Victor Grayson
Kirklees Metropolitan Borough Council
Development Management

Our ref: RA/2024/147506/01-L01
Your ref: 2024/92283

Date: 01 October 2024

**REDEVELOPMENT OF MARKET WITH ADDITION OF MEZZANINE FLOOR.
DEWSBURY MARKET, 32 CLOTH HALL STREET, DEWSBURY, WF13 1QE.**

DMTP-BDP-00-XX-SK-S-0004

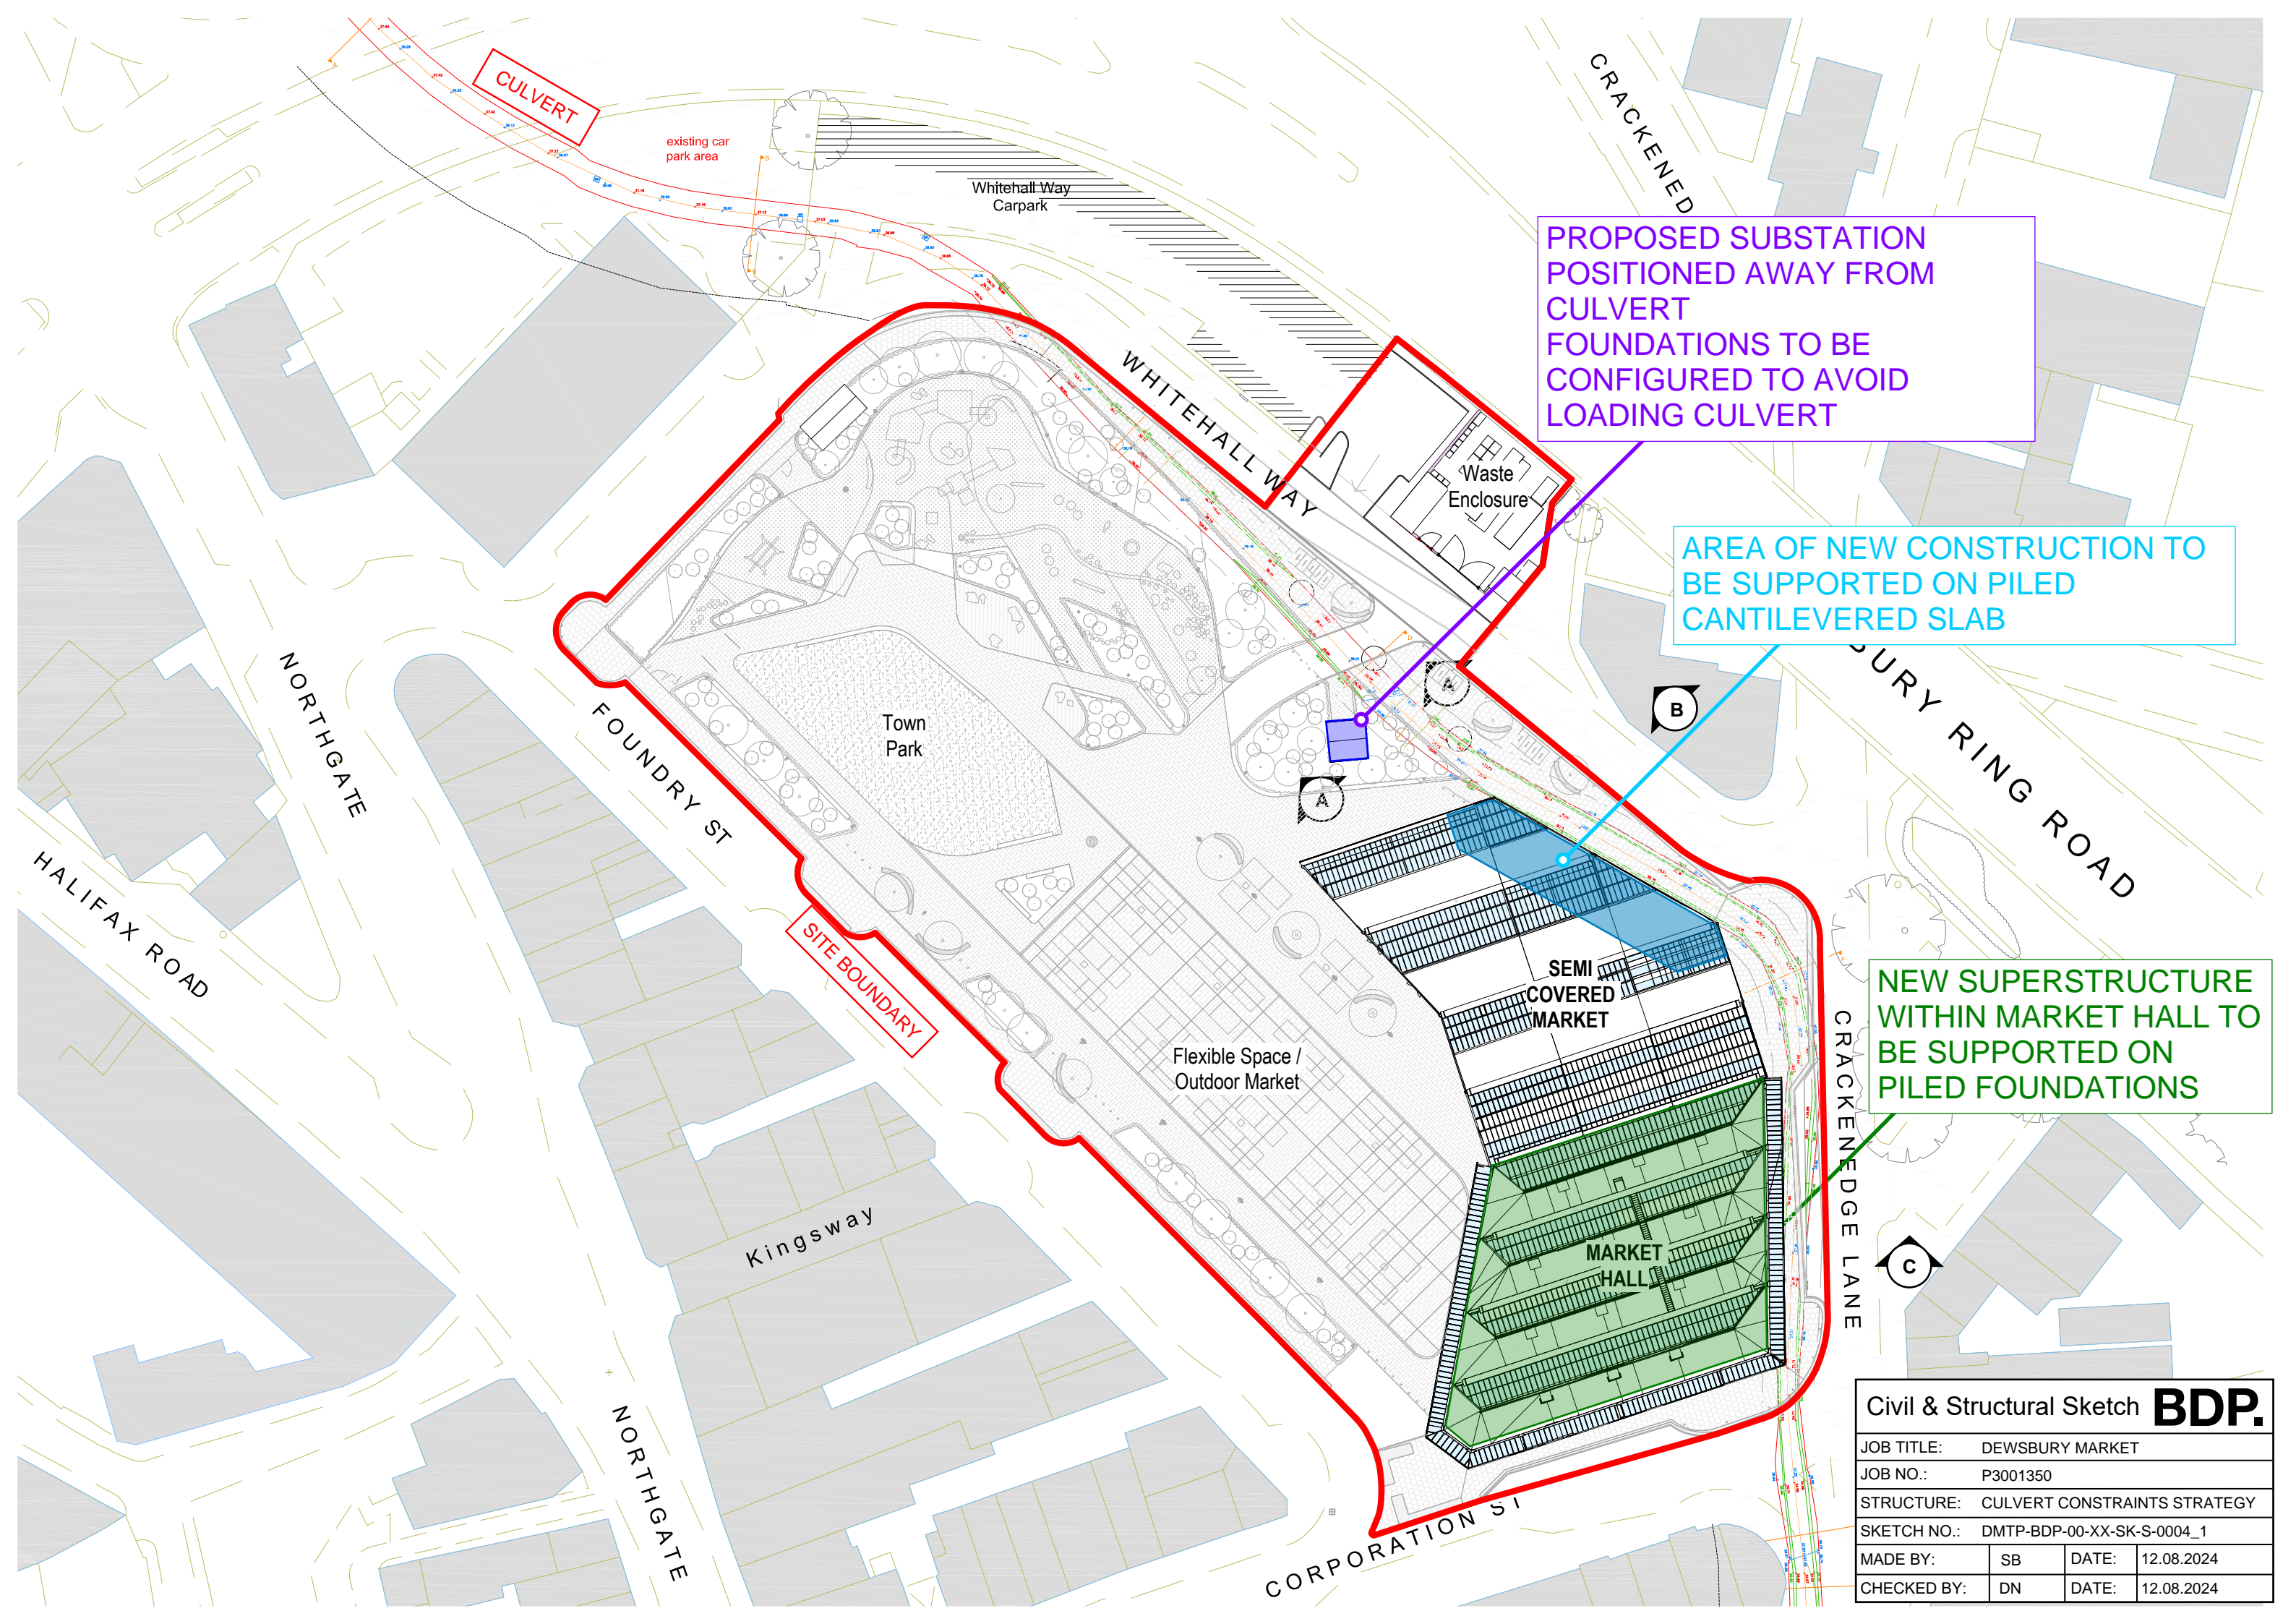
We object to this application as it involves building within 8 metres of a main river culvert. As submitted, it is unlikely that we would grant a flood risk activity permit for this application.

- The proposed development may restrict essential maintenance and emergency access to the culvert. The permanent retention of a continuous unobstructed area is an essential requirement for future maintenance and/or improvement works.
- The proposed development may adversely affect the construction and stability of the culvert, which will compromise its function. The proposal may therefore increase the risk of flooding nearby.

- It is unclear whether any new vertical or horizontal loading will be placed on the culvert and if they would have a detrimental impact.
- Please assess whether any temporary works within 8 m of the will cause no detrimental impact during construction.
- Please confirm and explain how there will be no impact on existing access for essential maintenance as a result of the development.
